Application by National Grid Electricity Transmission Plc for the Bramford to Twinstead Reinforcement

The Examining Authority's first written questions Issued on 13 October 2023

TITLE  
 2.11.7 DESIGN AND LAYOUT PLANS: STOUR VALLEY EAST CABLE SEALING END COMPOUND

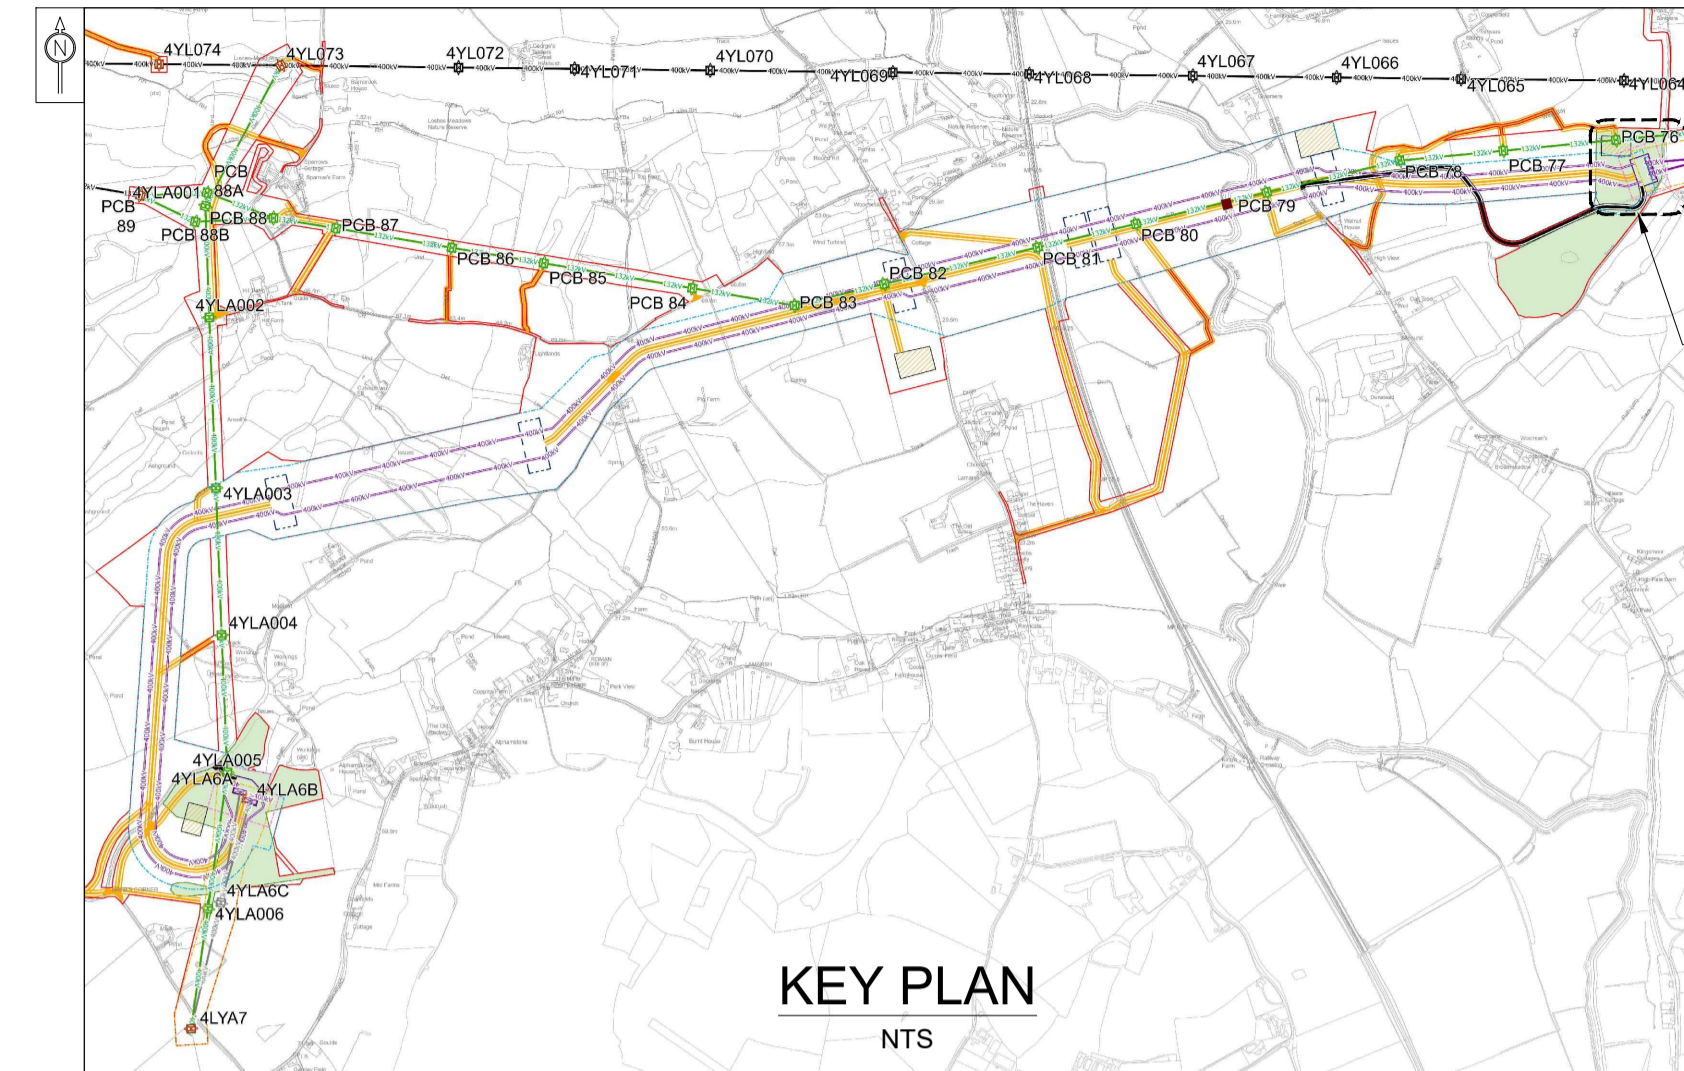
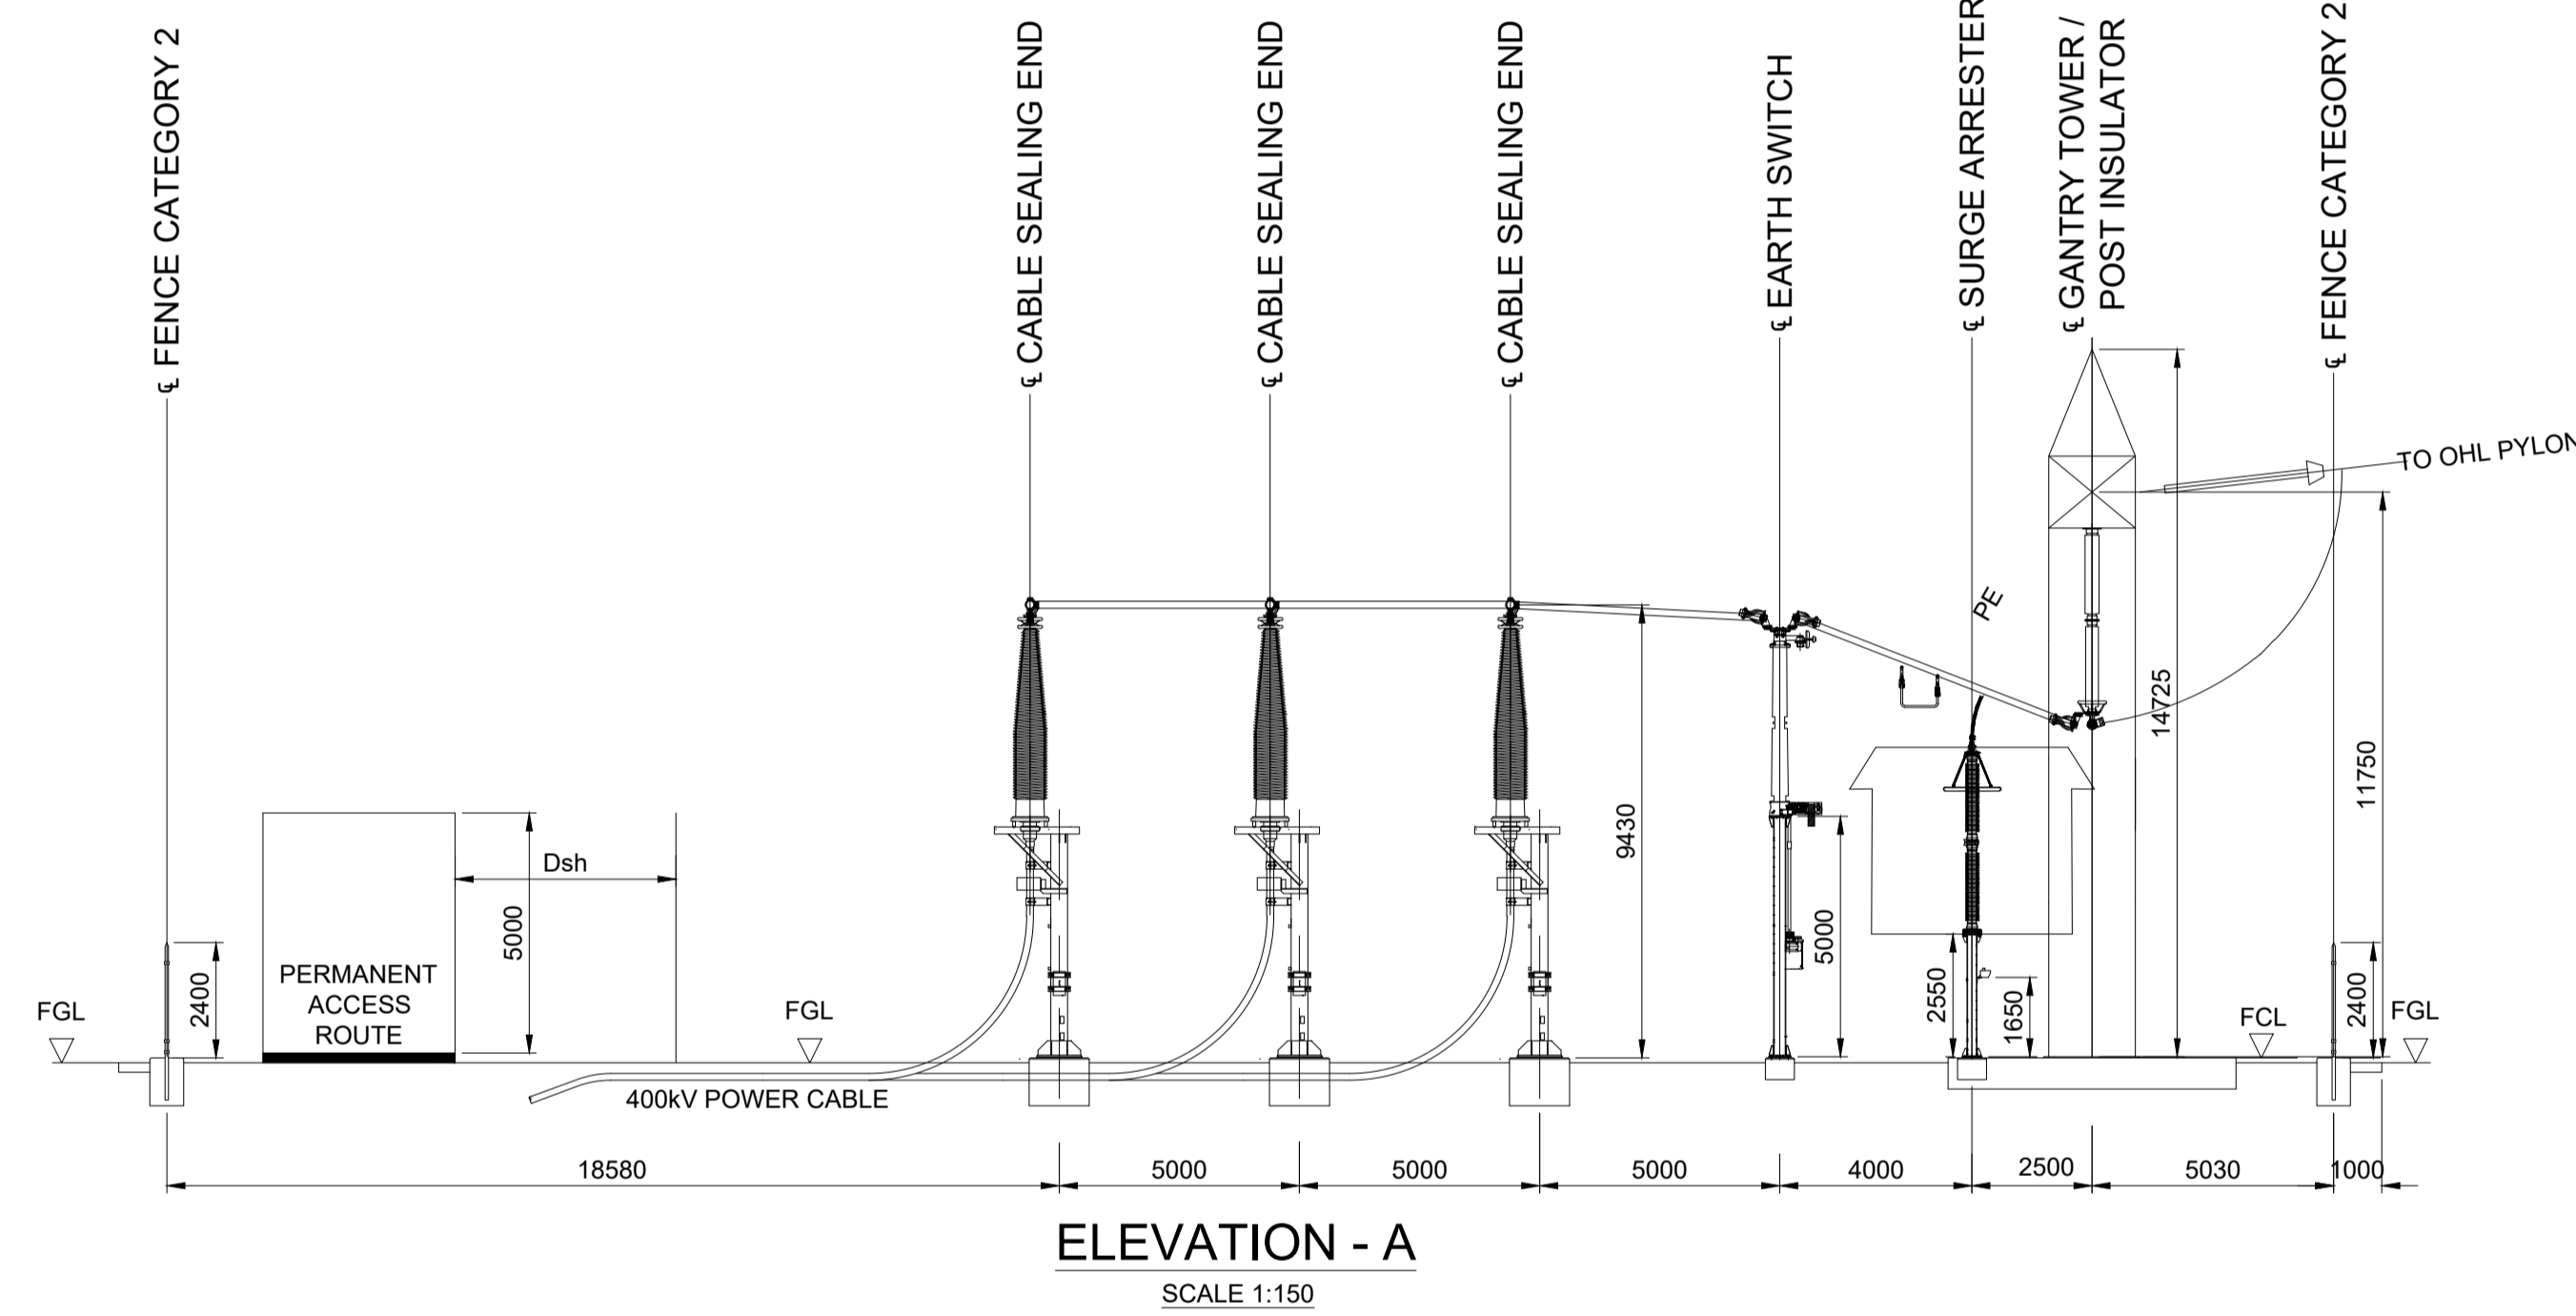
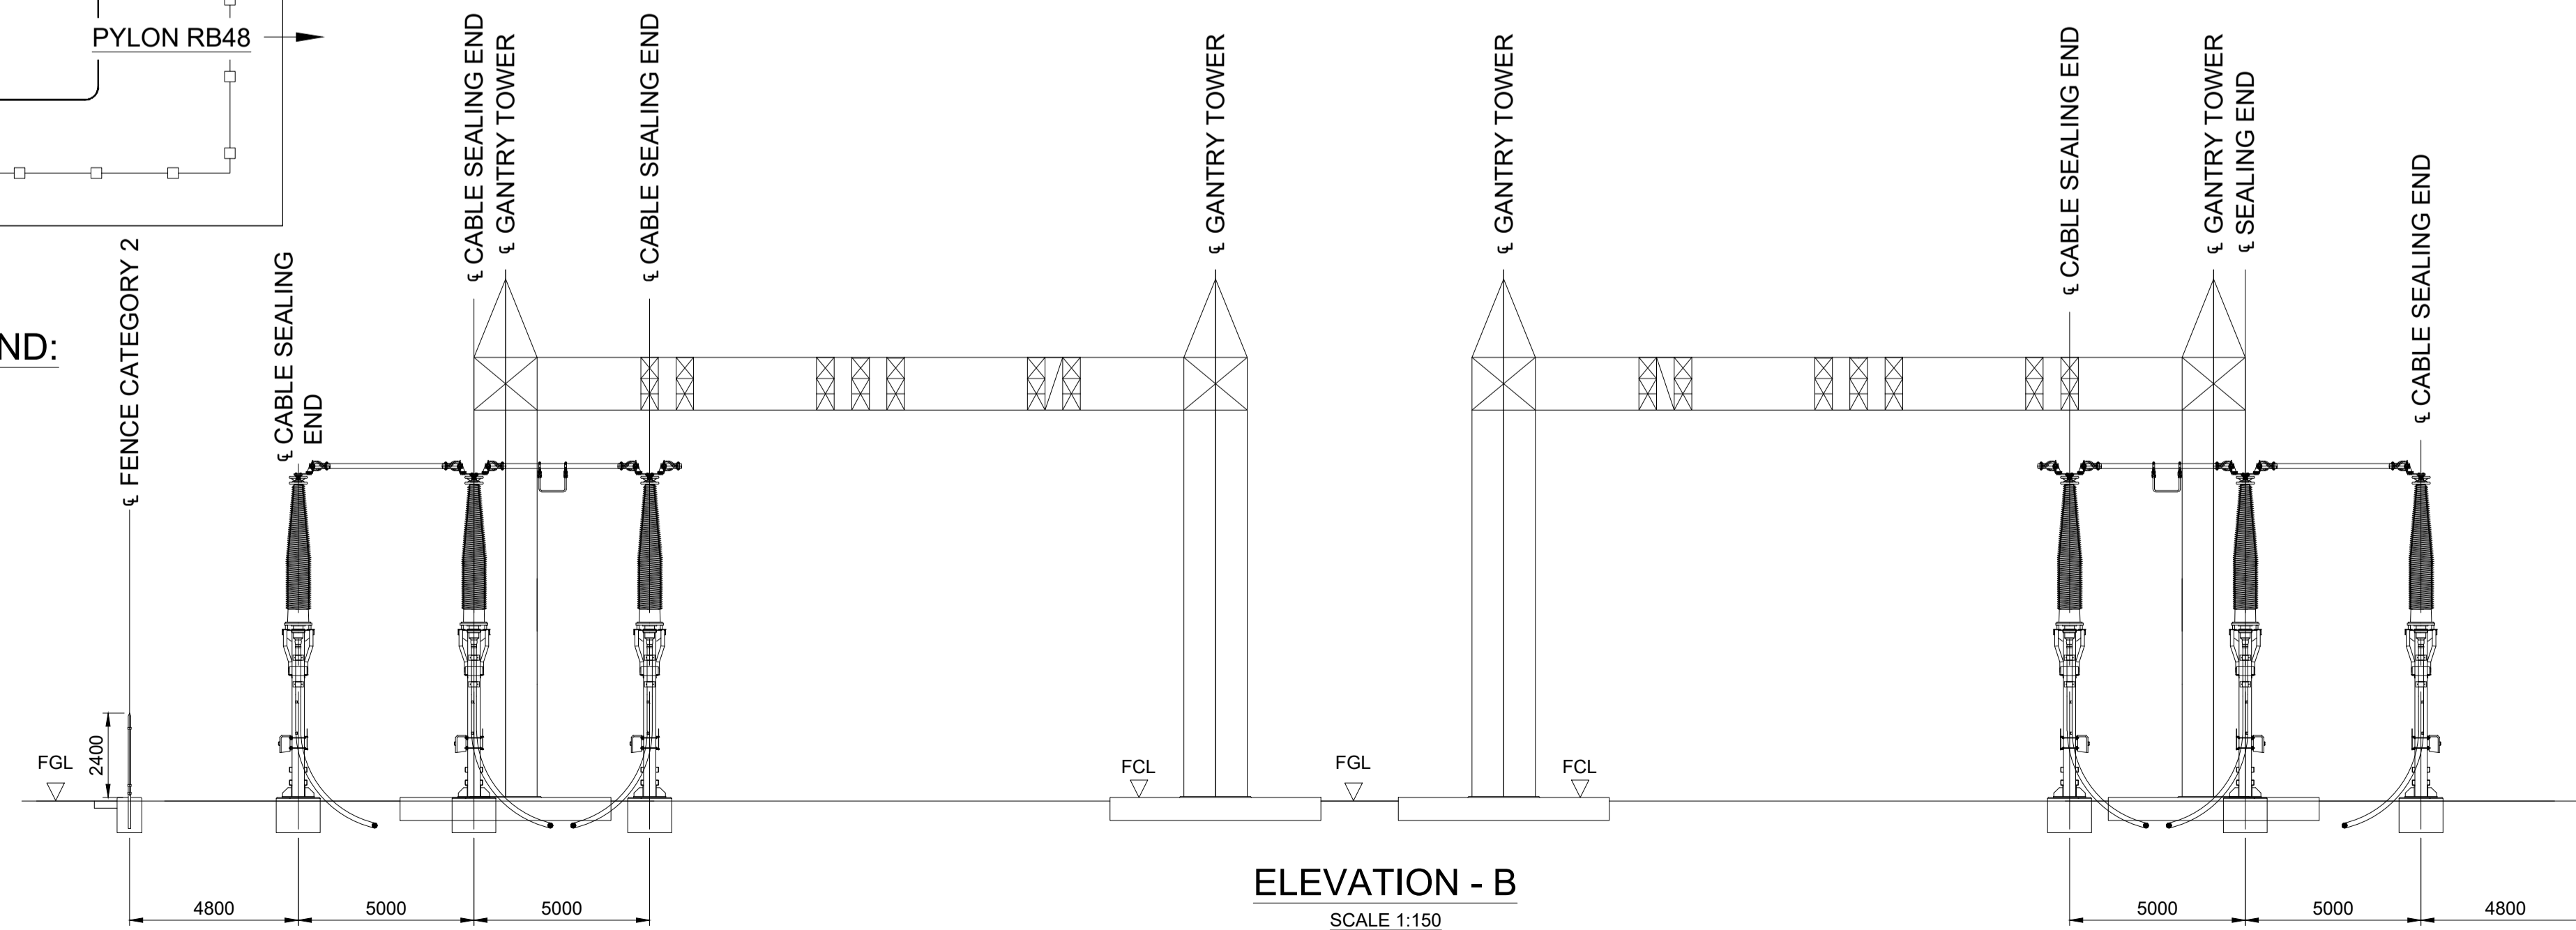
HE1.8.3	Historic England	If not covered in your Written Representation, can you elaborate on your specific concerns in relation to the cable sealing end compound close to the Polstead Conservation Area [RR-036].	<p>We no longer have concerns relating to the cable sealing end compound close to the Polstead Conservation Area.</p> <p>The Dedham Vale East CSE compound was moved approximately 1km further away from its original location and was placed between two blocks of woodland to</p>

Reference	Question to:	Question	
			screen the site in response to Historic England's feedback.
HE1.8.9	Historic England Babergh DC Mid Suffolk DC Suffolk CC The Suffolk Preservation Society	<p>A number of parties have raised issues in relation to effects on the Grade I listed Hintlesham Hall and the associated listed buildings. The Applicant's proposals here are said to be based on the micrositing of towers agreed with Historic England prior to the project being put on hold in 2013, but the proposed Limits of Deviation proposed would allow pylons to vary from the indicative agreed positions.</p> <p>Do you consider this approach acceptable in the area within the setting of Hintlesham Hall?</p> <p>Are there any implications in relation to avoidable harm to Hintlesham Hall?</p> <p>Can you confirm if there is a specific area, component or extent of the proposed Limits of Deviation that is of concern, and any harm you consider could arise.</p> <p>Should any changes or deviation be restricted to those agreed by the relevant local planning authority and Historic England?</p> <p>Paragraph 8.11.6 of the ES [APP-076] addresses the sensitivity testing that was carried out in relation to pylon locations and alignment and concludes that, '<i>the pylons could be located anywhere within the parameters of the LoD (including the vertical LoD) without resulting in significant effects to heritage assets.</i>' Do you agree with this conclusion?</p> <p>Is the sensitivity testing and conclusion further described in the Applicant's Hintlesham Hall Assessment [APP-128] sufficiently evidenced, and do you agree with the conclusion?</p>	<p>We expressed concerns in our Written Representation regarding the Limits of Deviation around Hintlesham Hall. We do not think the limits of deviation and potential changes to the positions of pylons RB3 and RB4 have been fully taken into account. We have concerns that the limits of deviation could result in avoidable harm to the significance of Hintlesham Hall.</p> <p>Our concerns relate specifically to the siting of pylons RB8 and RB9. If they were moved they would be in a key view from the stable block of Hintlesham Hall (shown in viewpoint HV01). We consider this would increase the level of harm considerably and would be avoidable.</p> <p>We would therefore like to see additional measures added to protect the view out from the stable block of Hintlesham Hall (shown in viewpoint HV01) and prevent the relocation of pylons RB8 and RB9.</p> <p>We would agree that any changes or deviation should be restricted a way to achieve this as suggested would be to seek agreement from the relevant local planning authority and Historic England?</p> <p>Paragraph 8.11.6 of the ES [APP-076] addresses the sensitivity testing that was carried out in relation to pylon locations and alignment and concludes that, '<i>the pylons could be located anywhere within the parameters of the LoD (including the vertical LoD) without resulting in significant effects to heritage assets.</i>' In the case of</p>
